Our Ref: SDNP/20/01305/ADJAUT
Contact Officer: Nat Belderson
Tel. No.: 01730 814810

Neighbouring Authority Consultation

Proposal: ADJACENT AUTHORITY CONSULTATION - A/32/20/PL - Erection of 1 No. detached low-profile bungalow with attached garage. This application is a Departure from the Development Plan & may affect a Public Right of Way.

Address: White Lodge , Hangleton Lane , Ferring , BN12 6PP

PROPOSED ELEVATIONS 1:100@ A3 / 1:50 @ A1

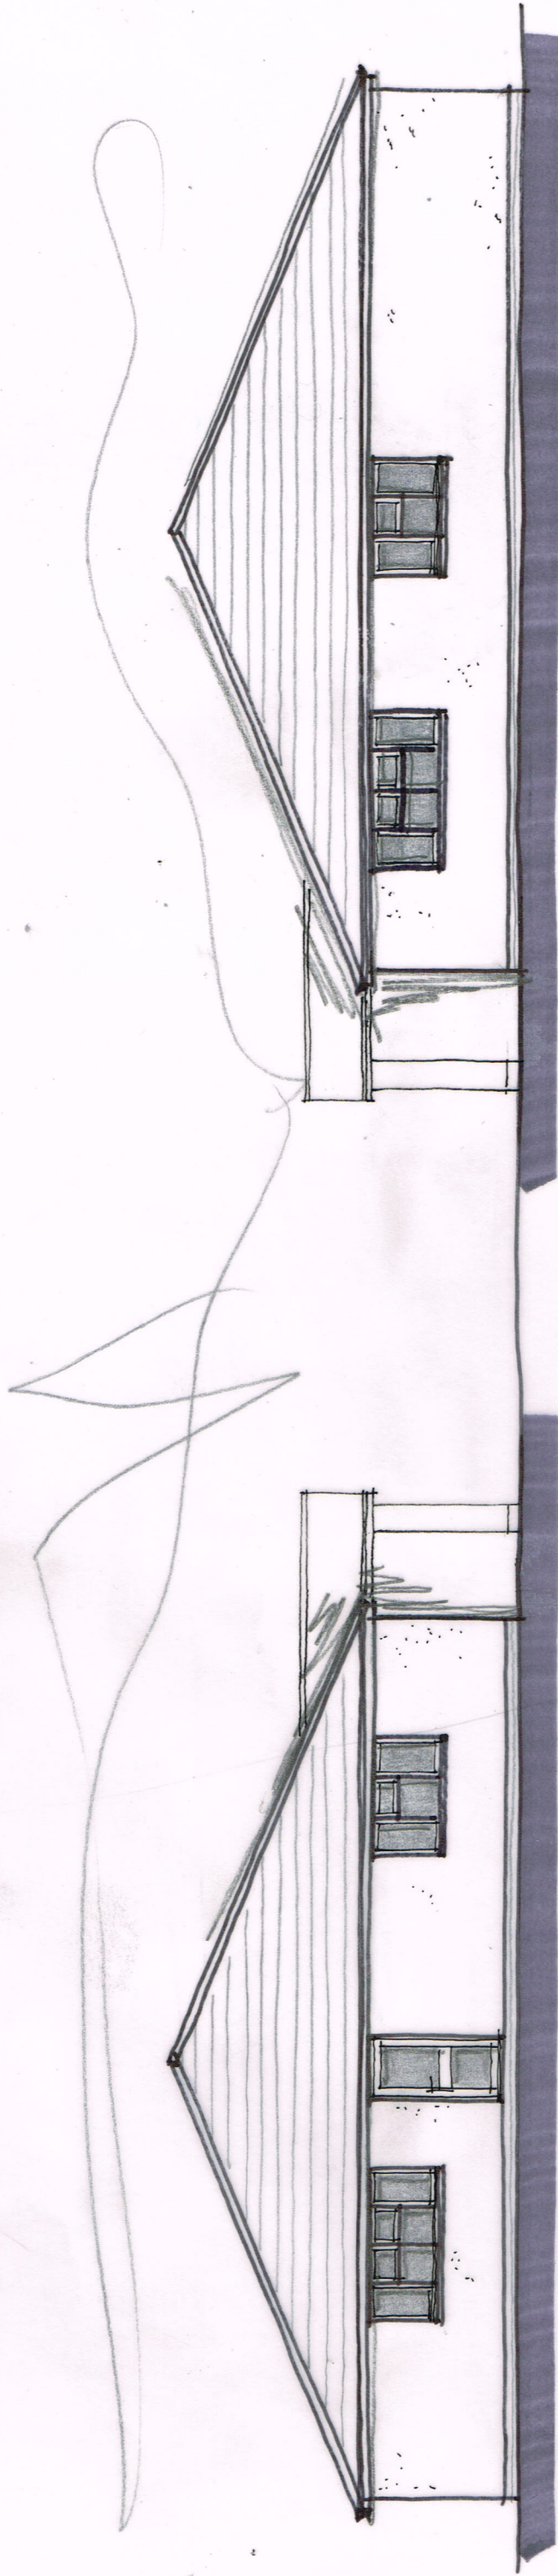
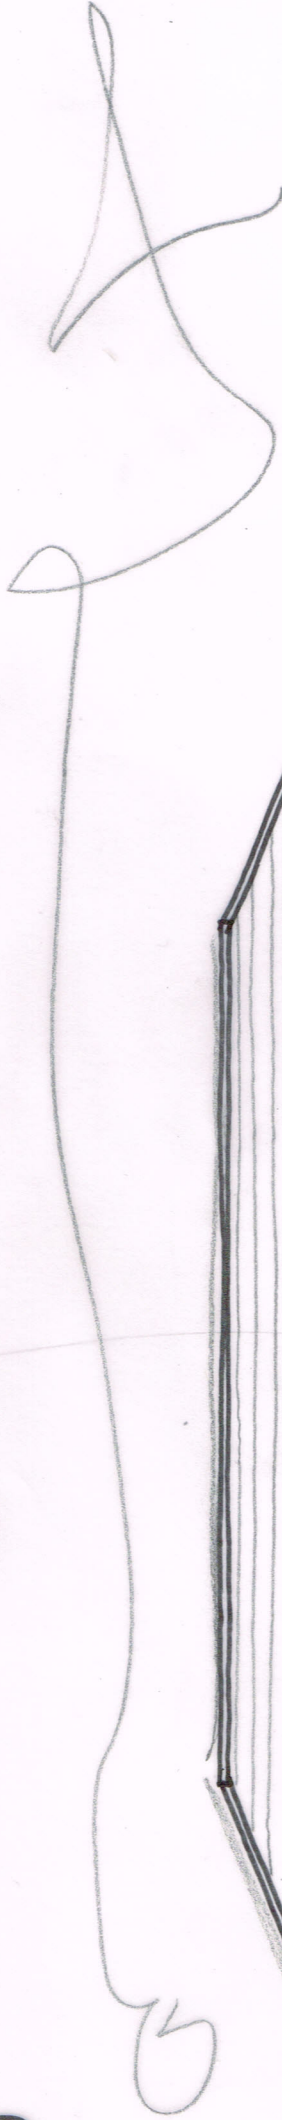
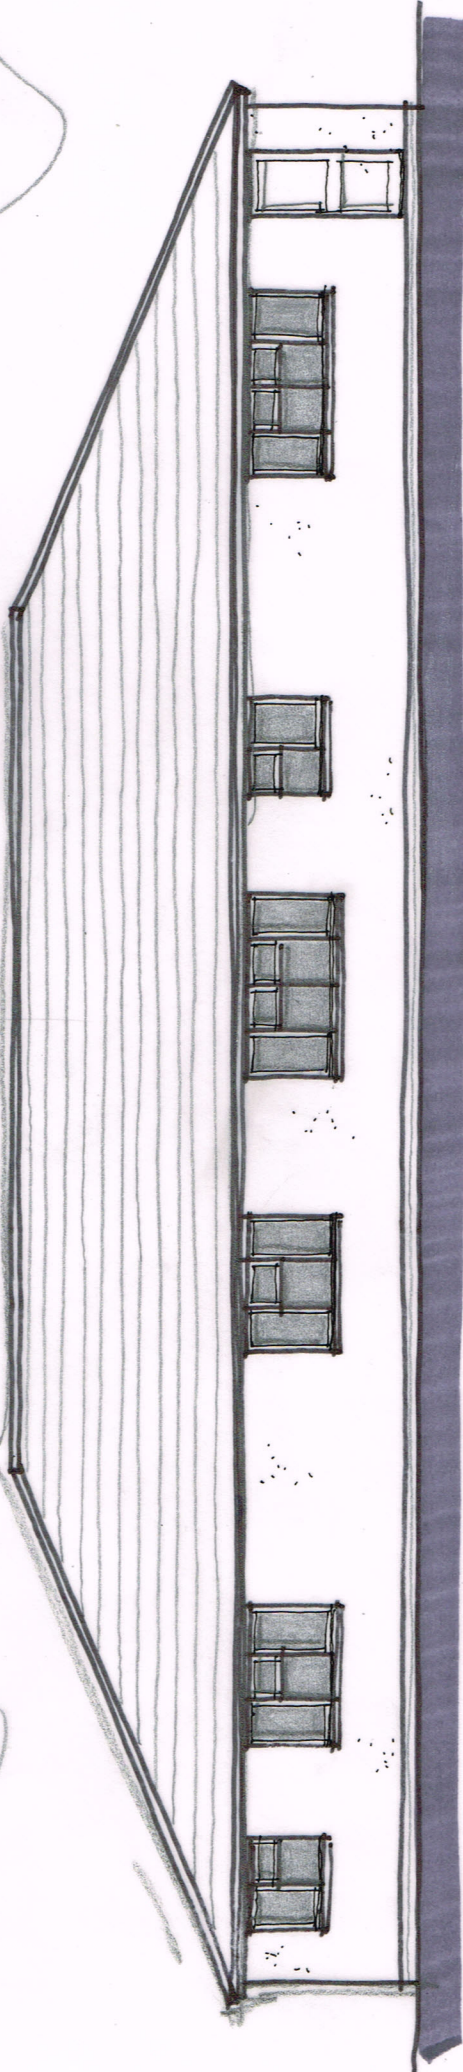
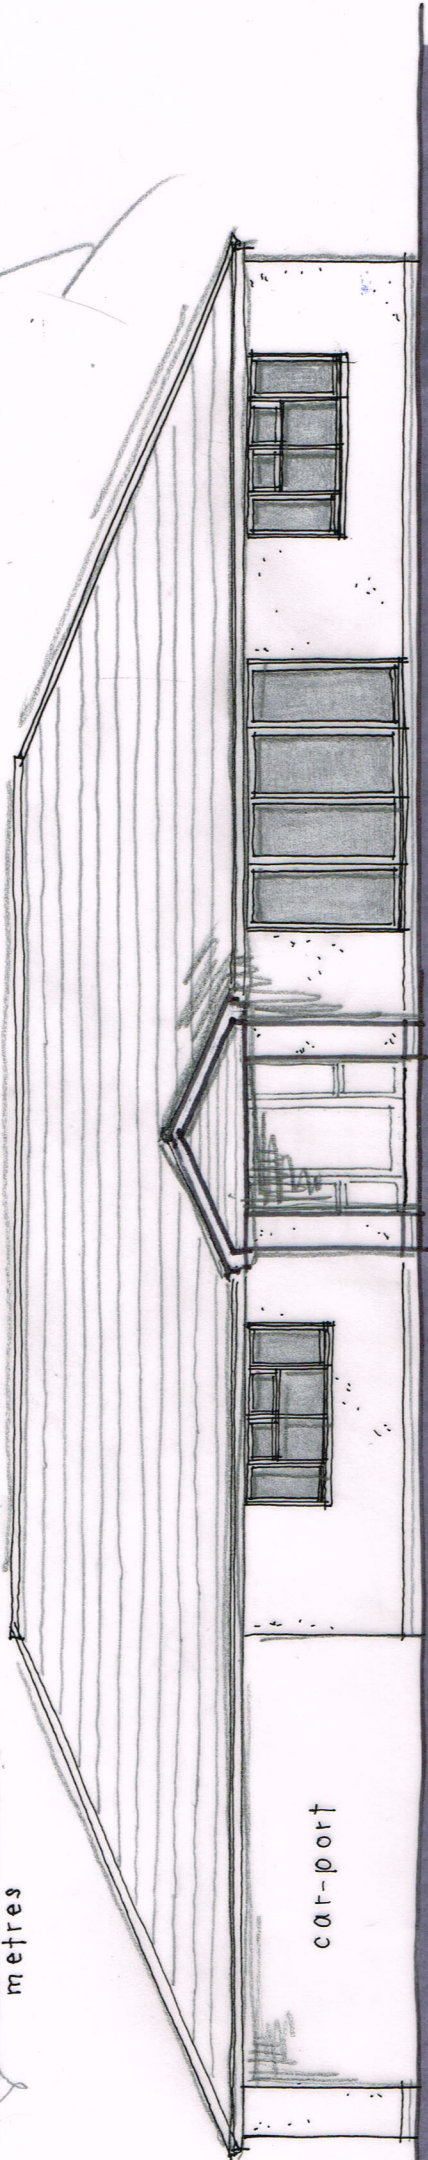
Should the District Council consider that there are compelling circumstances that warrant a new permanent dwelling on this site, we would encourage the use of a more appropriate roofing material (such as a dark clay tile) in place of the currently proposed grey Marley Modern given that the roof would be the most visible element in distant views from within the SDNP (such as from Highdown Hill). Notwithstanding the proximity to glasshouses, we would also recommend controls on the use of external lighting, both in recognition of the nearby South Downs Dark Skies Reserve, and in light of the comments from your ecological adviser.
